HERON MEADOW CIC
Doit Lane,
Roydon,
Norfolk
IP22 5XR

Planning Application reference: No: EN020027

Response to National Grid's latest 'Action Point 27 - Waveney Valley, Draft Constraints Plan'

Title:
Action Point 27: Waveney Valley (including Snow Street, Roydon Fen and Wortham Ling) - Draft Constraints Plan

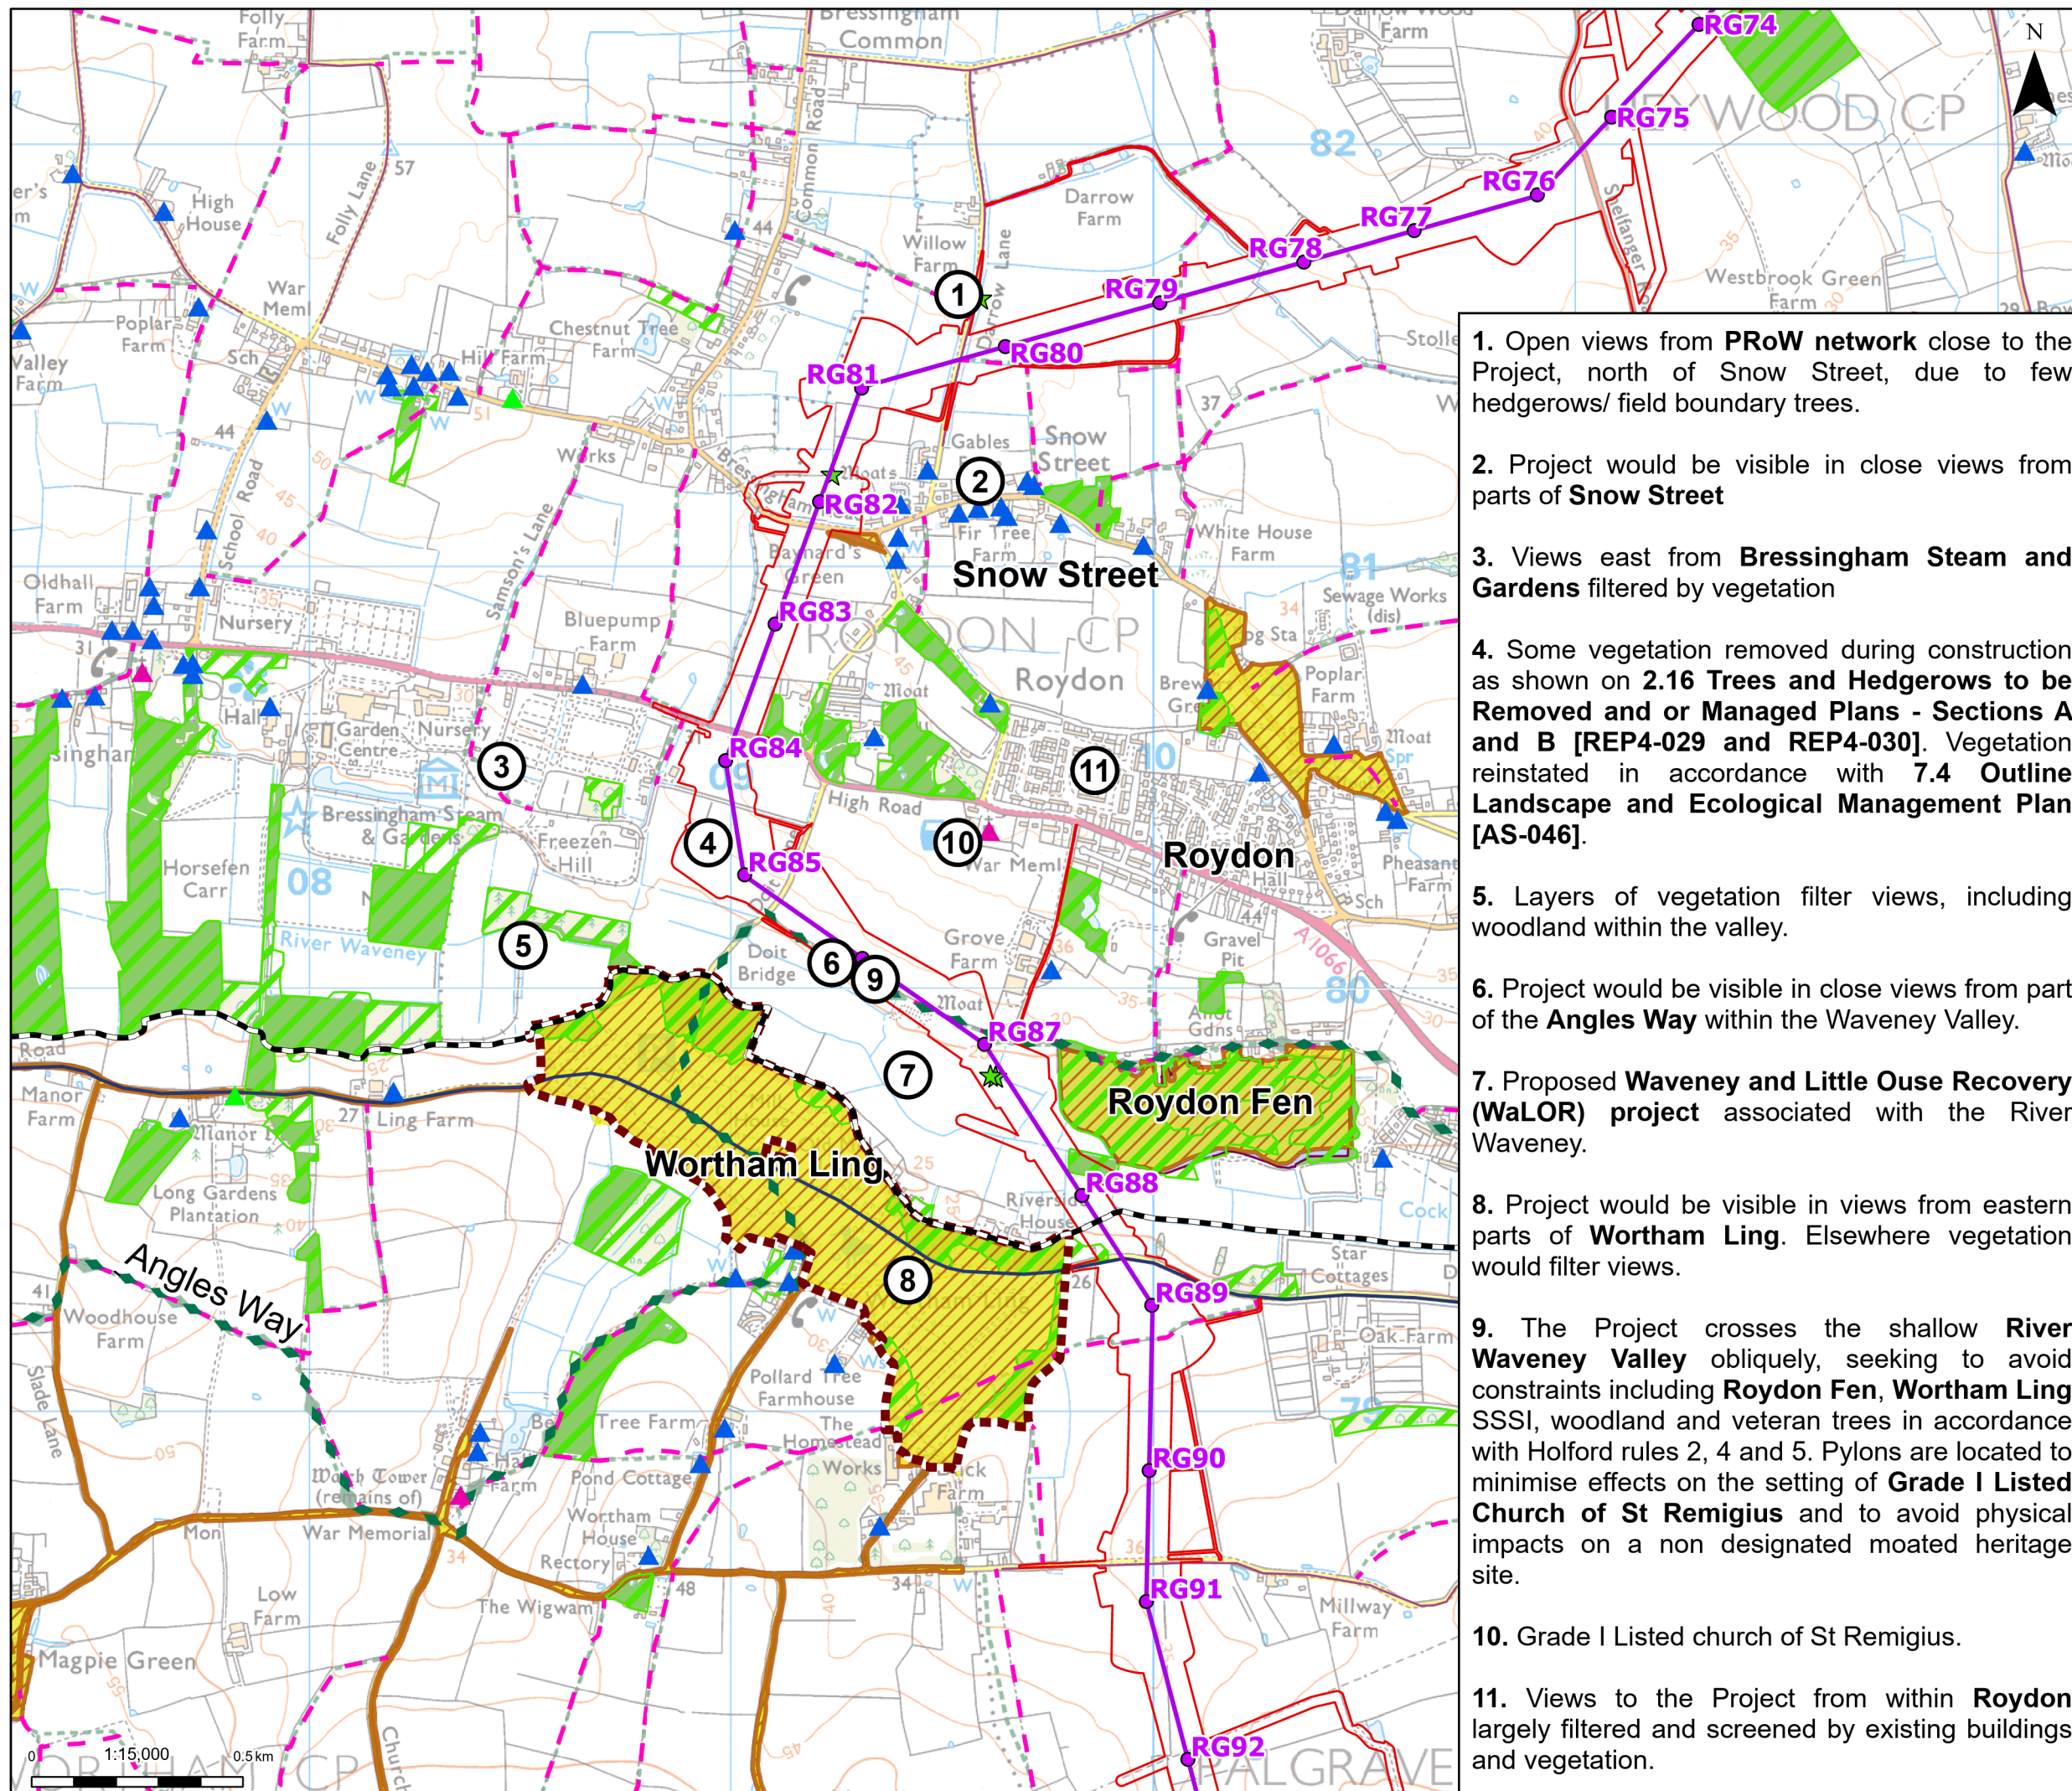
1. On page 10 of document EN020027-003572-8.4.12.2 Response to ISH2 Actions. Point 6. NG admit that 'Project would be visible in close views from the Angles Way within the Waveney Valley'. Heron Meadow is in exactly this location and is within 200m of RG085. The close proximity of the High Voltage powerlines will be incompatible with Heron Meadow continuing to be able to offer a place of sanctuary and healing for those suffering with trauma and difficulties associated with neurodivergence. I would therefore be forced to close this project. There are many studies which demonstrate the adverse effects of EMF waves on humans, particularly neurologically sensitive individuals.

2. NG make claims to the 50m high pylons becoming 'filtered by vegetation' through the Waveney Valley. This notion is without conceivable possibility since the tallest established trees in this area are approx. 30 metres high. The Pylons will therefore dwarf all 'vegetation'; furthermore, any new trees planted by NG will take approximately 80 years to reach their full height – around the time that these pylons will need to be decommissioned.

3. As the landscape in this area has only very gently sloping aspects the pylons will not be visually screened by steep hillsides as is the case in some areas of the West County, they will dominate the horizon in all directions.

4. On page 11 NG describe 'connective green enhancements' and 'connective blue enhancements'. I protest these terminologies as disingenuous and misleading. There is nothing about the N2T project which will enhance the existing beauty, biodiversity and rural tranquillity of the Waveney Valley. Please consider alternatives such as the subsea or DC underground options.
